Road Safety Audit Report

**Incorporating
Stage 1 Completion of Preliminary Design.**

Proposed Access off the A259 New Road, Rustlington

Client:
Commercial Development Projects Ltd

Title
HIGHWAY ACCESS PLAN

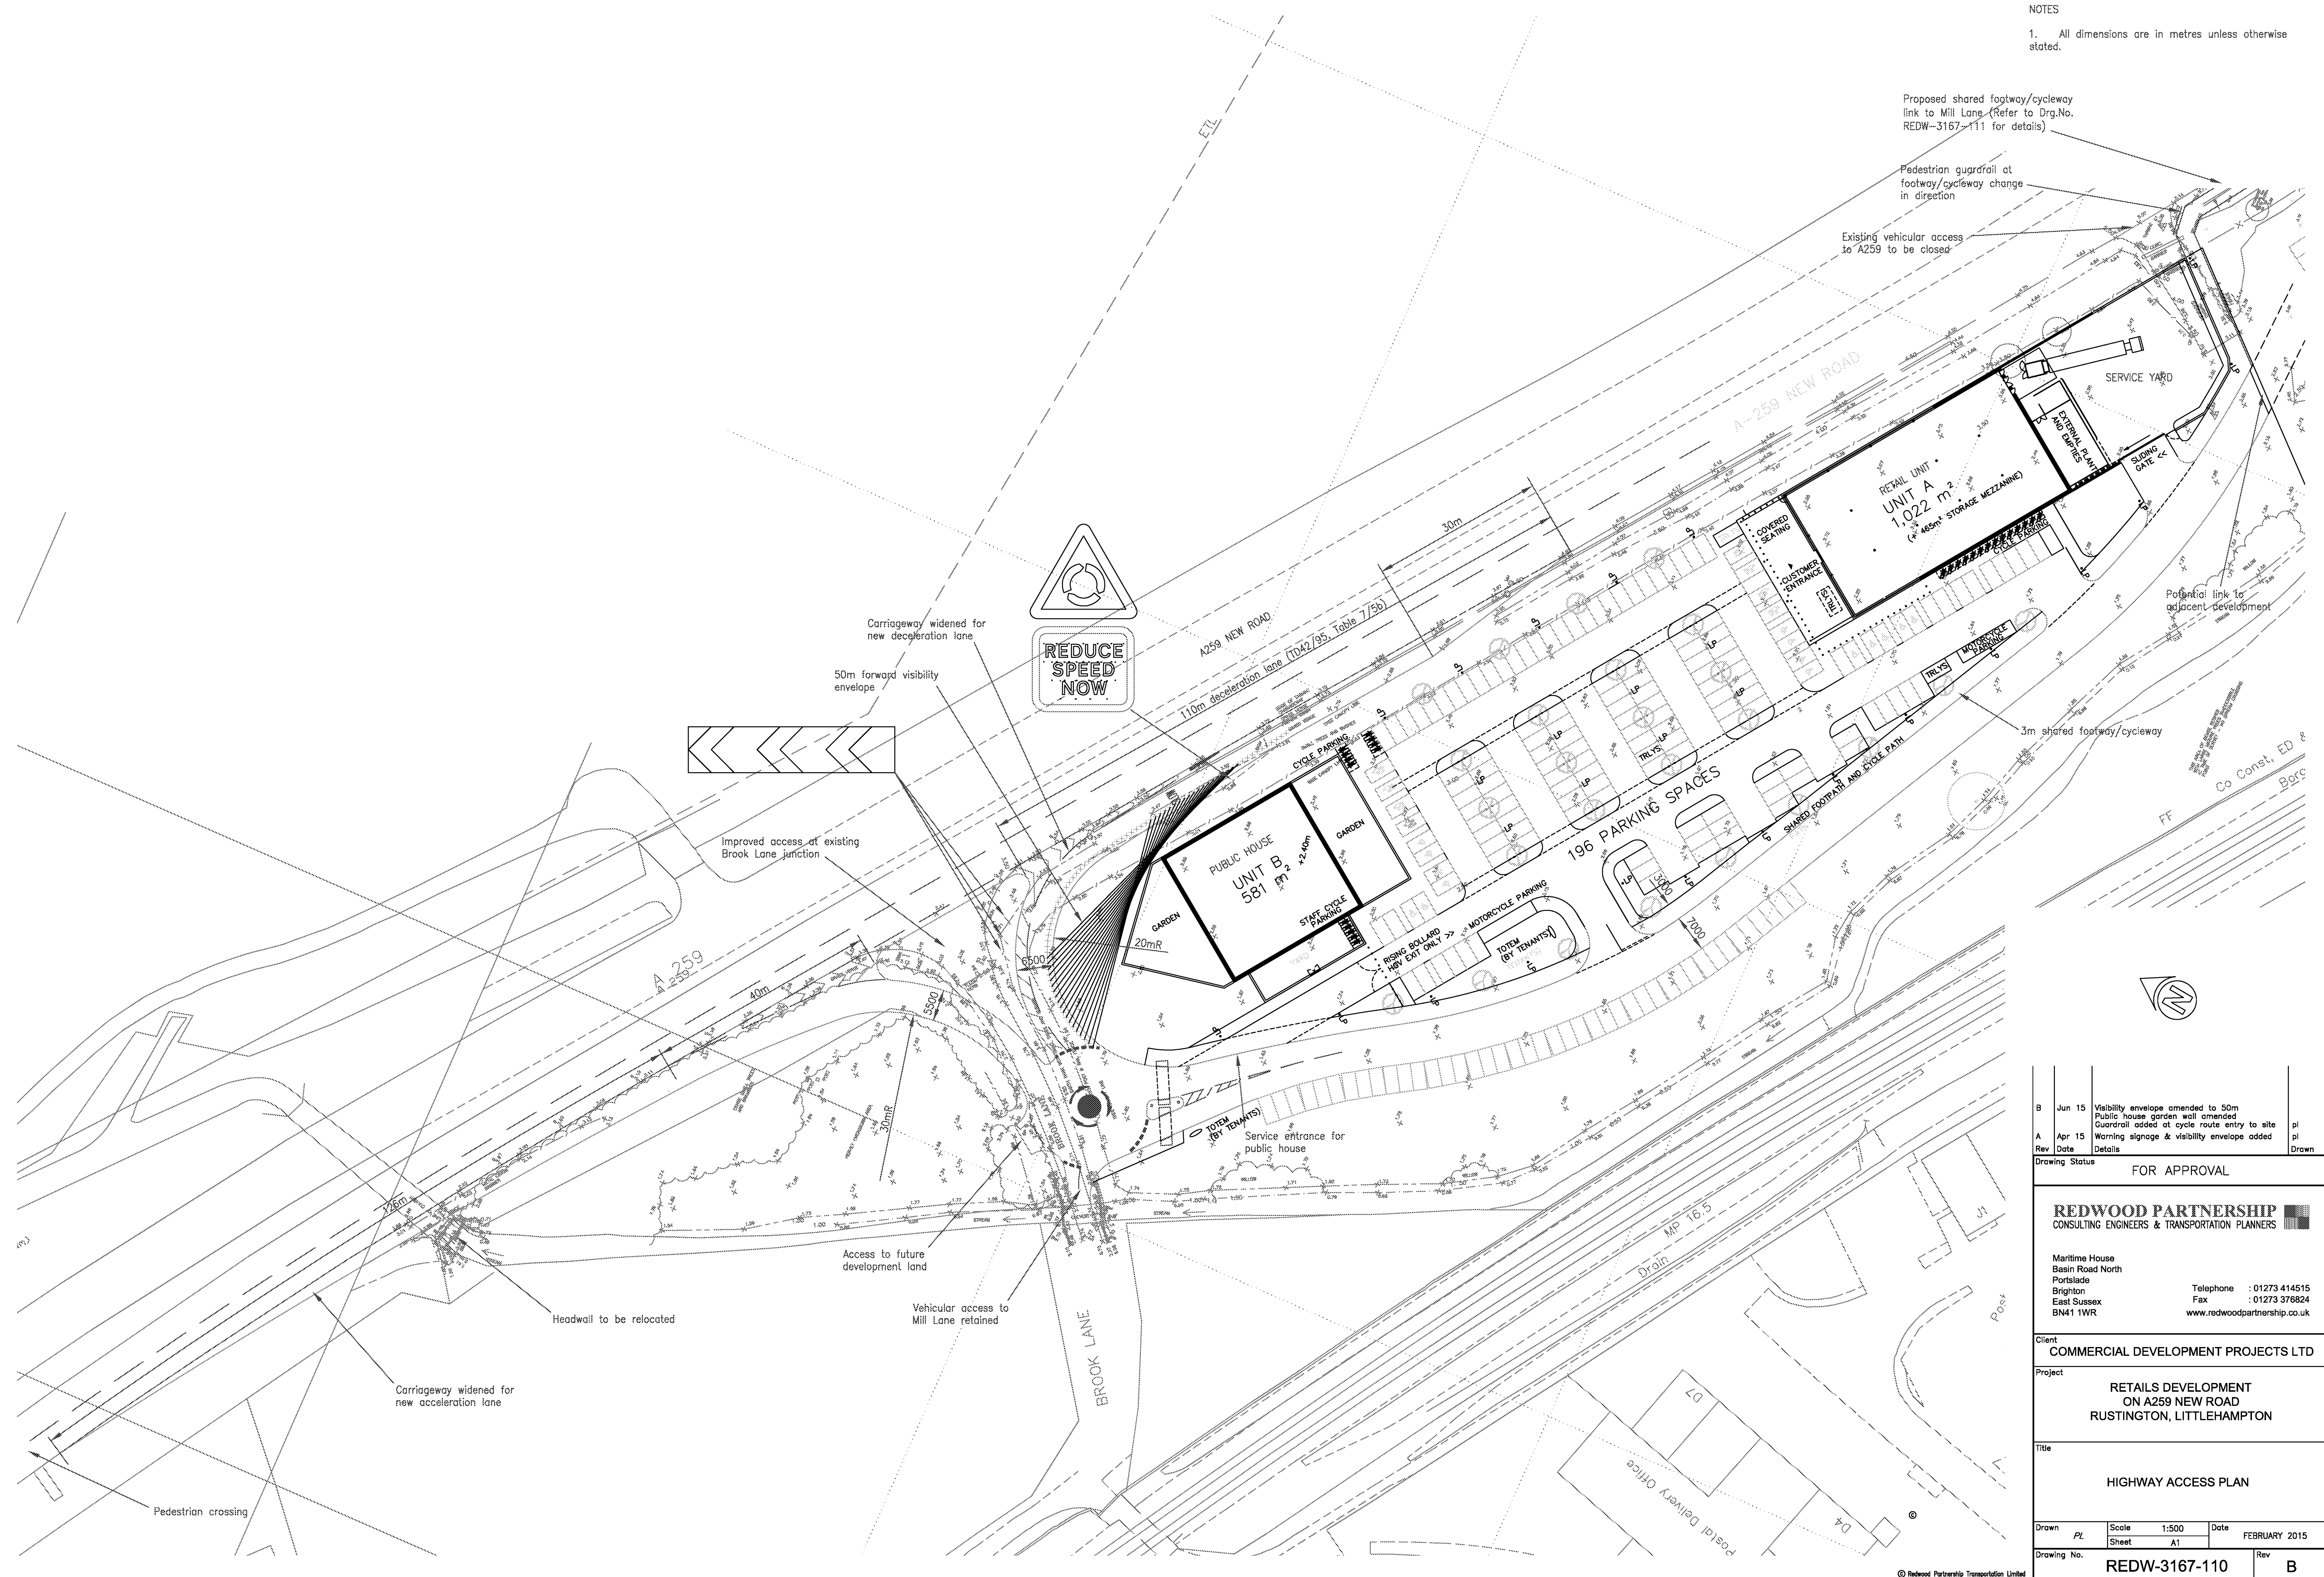
Audit Item No.	Audit Team Observation	Audit Team Recommendation	Designer / Scheme Response
A.1	GENERAL		
A.1.1	<i>The proposals to improve an existing access off the A259, New Road to facilitate the safe access and egress to / from a proposed development consisting of a food retail store and pub/restaurant at this location does not raise any road safety concerns in general at this stage, provided that the items raised within this audit in the following specific sections are addressed appropriately. The access road associated with the development is of sufficient length to allow for the free flow of vehicles off the A259 without the need to stop to allow vehicles to access and egress parking spaces.</i>		
A.2	LOCAL ALIGNMENT		
A.2.1	PROBLEM Tight entry corner radius Accident Type <i>Loss of Control</i> Location Entry radius from deceleration lane <i>The proposed deceleration lane is provided for vehicles to decelerate from the derestricted A259. Vehicles could therefore be travelling in excess of the speed required to safely manoeuvre around the 20 metre corner radius. This could result in vehicles losing control and striking the island.</i>	The appropriate chevron and warning signs should be installed in clear view of vehicles utilising the deceleration lane to ensure that drivers are aware of the corner. 	Chevron sharp deviation of route signs (Diag. 515) have been included on the central approach island as shown on Drg.No. REDW-3167-110-Rev A

Audit Item No.	Audit Team Observation	Audit Team Recommendation	Designer / Scheme Response
A.2.2	PROBLEM Restricted visibility around the exit corner radius Accident Type <i>Shunt</i> Location Inside of exit radius to the acceleration lane <i>Forward visibility vehicles accelerating from the roundabout to the acceleration lane to vehicles utilising the acceleration lane, is restricted by vegetation. Therefore drivers will not have a clear view of preceding vehicles. This could result in shunt type accidents should a driver hesitate and stop along the acceleration lane.</i>	Vegetation should be cleared to the appropriate level to allow for the clear forward visibility.	Vegetation will be cleared to a distance of 3m from the kerb line of the site at the radius of the site egress. The verge area adjacent to the carriageway will be offered for adoption as Public Highway

Audit Item No.	Audit Team Observation	Audit Team Recommendation	Designer / Scheme Response
A.3	JUNCTIONS		
A.3.1	PROBLEM Forward visibility to the roundabout is restricted Accident Type <i>Shunt type accidents</i> Location Roundabout Forward visibility to the give-way road marking at the roundabout from the deceleration lane is restricted to approximately 50 metres based on the building line of the adjacent pub/restaurant. This could be further restricted should a fence be erected around the associated grounds and could result in shunt type accidents where vehicles are stopped at the give-way.	Warning signs should be installed to ensure that approaching vehicles are aware of the presence of the roundabout and the pub/restaurant should be restricted from erecting a fence where it blocks forward visibility. 	Forward visibility to the site roundabout is restricted due to a boundary wall proposed around the public house garden area. The achievable forward visibility envelope is shown on Drg.No. REDW-REDW-3167-110-Rev A. An advanced warning sign of roundabout ahead (Diag. 510) and REDUCE SPEED NOW supplementary sign (Diag. 511) and SLOW road marking is proposed in advance of the roundabout which will mitigate the reduced forward visibility to the roundabout give way.
